3/2021/1022 Loft Shay Farm Clitheroe Road Ribchester PR3 2YQ

Reference 3/2021/1022
Alternative Reference
Location Loft Shay Farm Clitheroe Road Ribchester PR3 2YQ
Proposal Proposed single storey extension, garage and modifications to existing dwelling as approved under planning reference 3/2021/0670
Footpaths Affected **Fp5 Ribble Valley Ribchester (3-35-Fp5)**
Possible 106
Map Ref 364079 / 438236
Contact Ben Taylor Tel : 01200 425111
Email : planning@ribblevalley.gov.uk
Response Date 11/12/2021
Path File Link V:\EPPS\EP\PROW\Path Files\03 Ribble Valley\35 Ribchester\03-35-005-Fp\03-35-005-Fp Planning Applications
Web
Link https://www.ribblevalley.gov.uk/site/scripts/planx_details.php?appNumber=3%2F2021%2F1022

Lancashire County Council – Public Rights of Way have identified Public rights of Way 3-35-FP5 running through the proposed development and have the following response:-

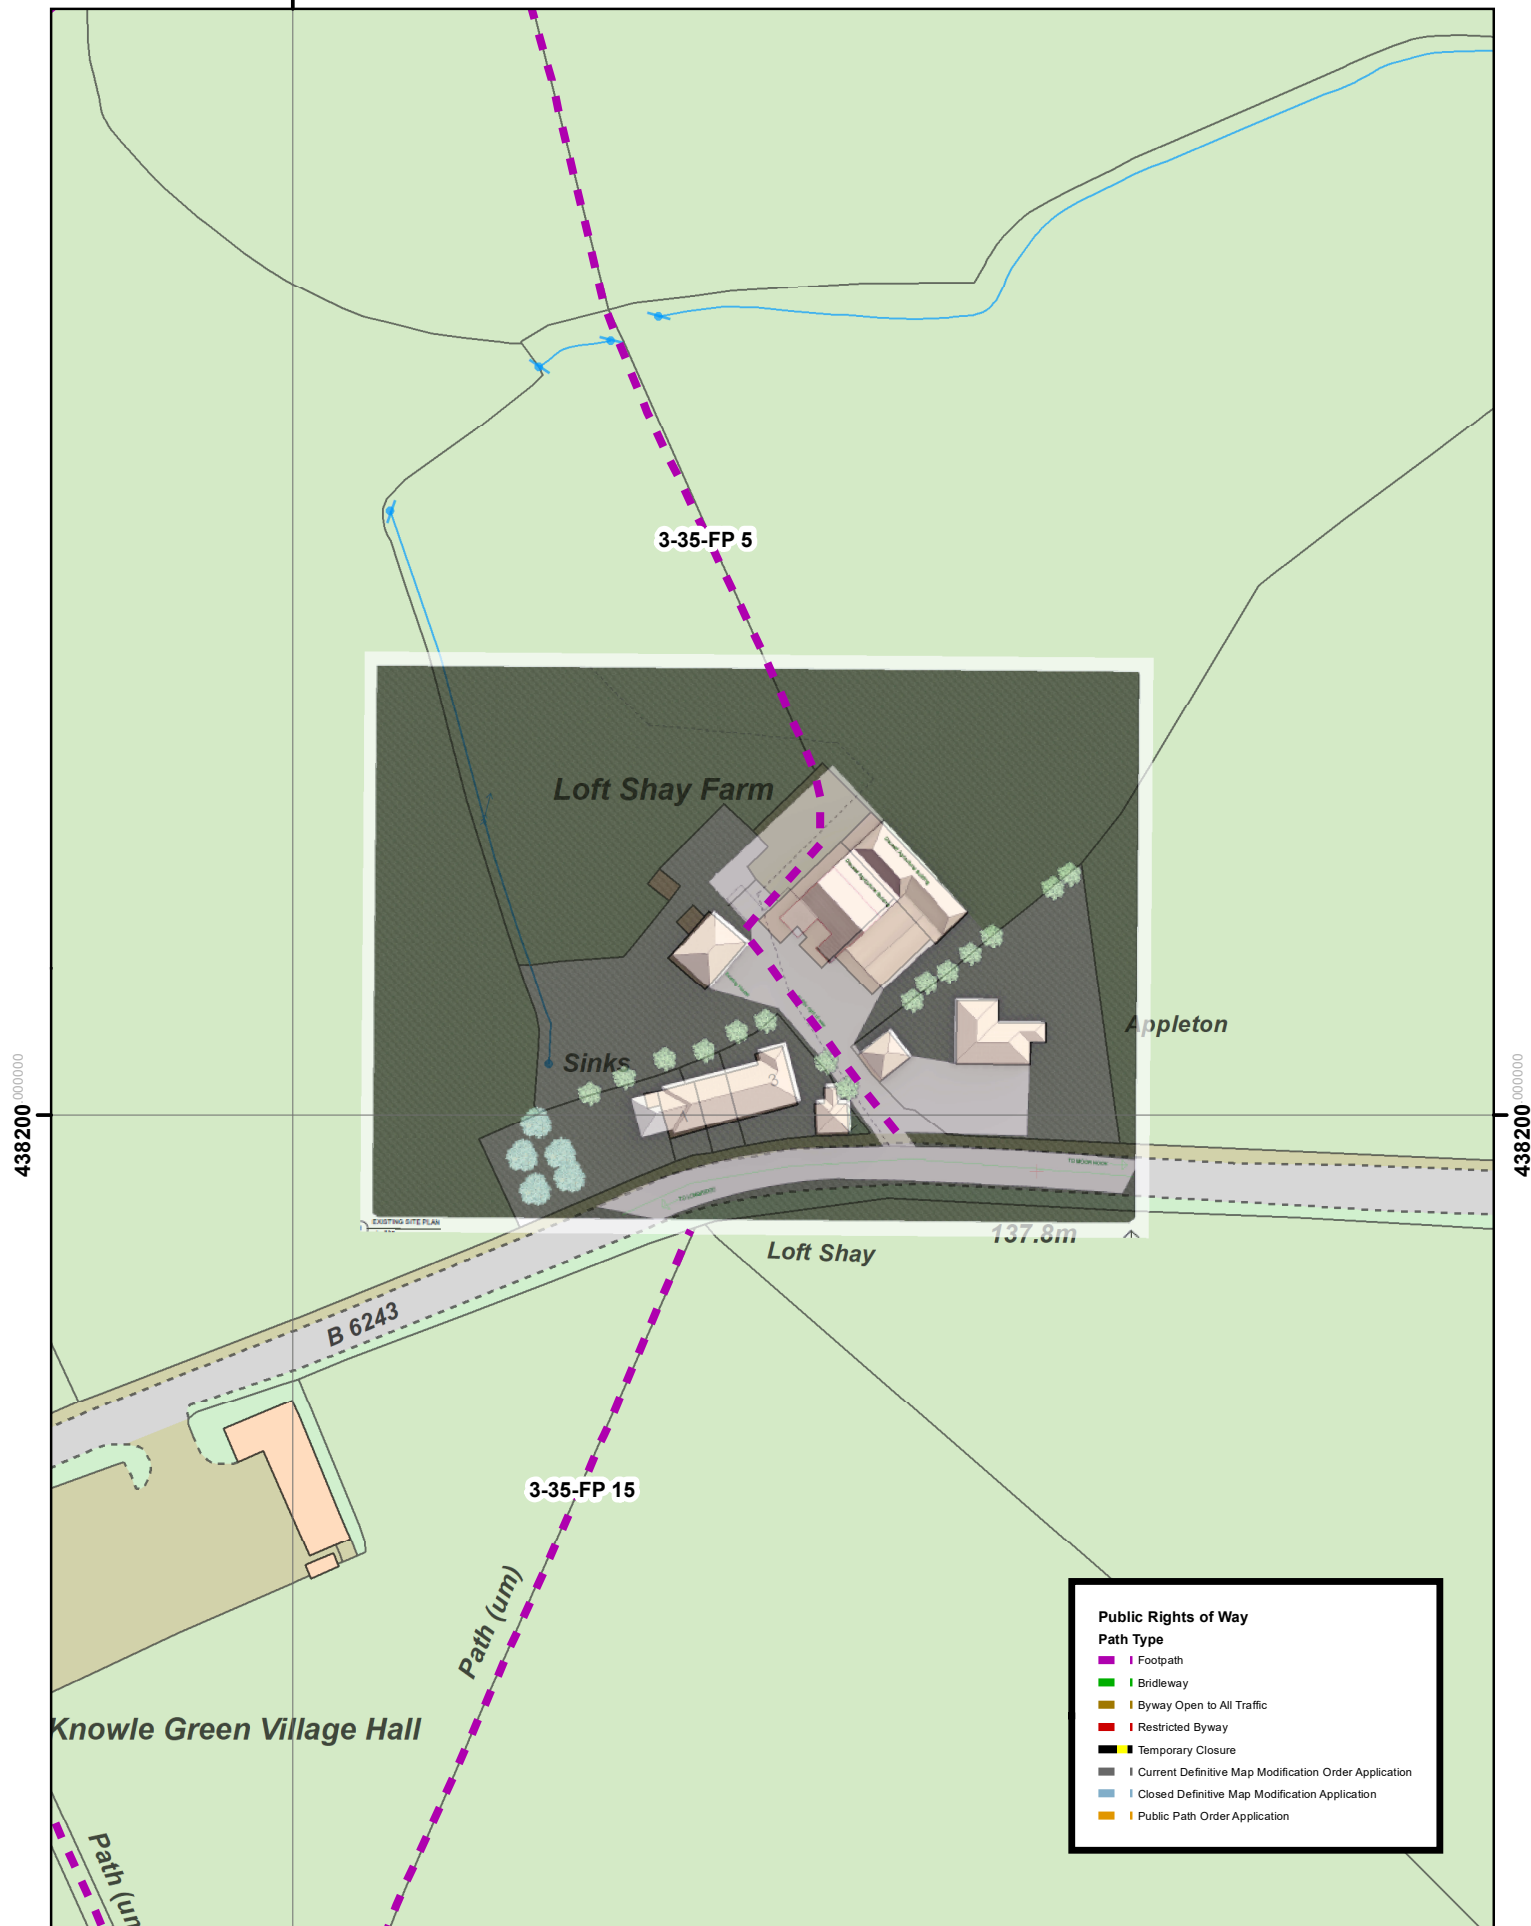
[a] Public rights of Way cannot comment on the proposed diversion as there is insufficient information in the application e.g. the diversion is not identified on the plan

Public right of Way 3-35-FP5 should not be obstructed at any time during the development by machinery, materials or vehicles as that would be an unlawful obstruction unless a Statutory Diversion is certified and in place prior to works commencing on the footpath.
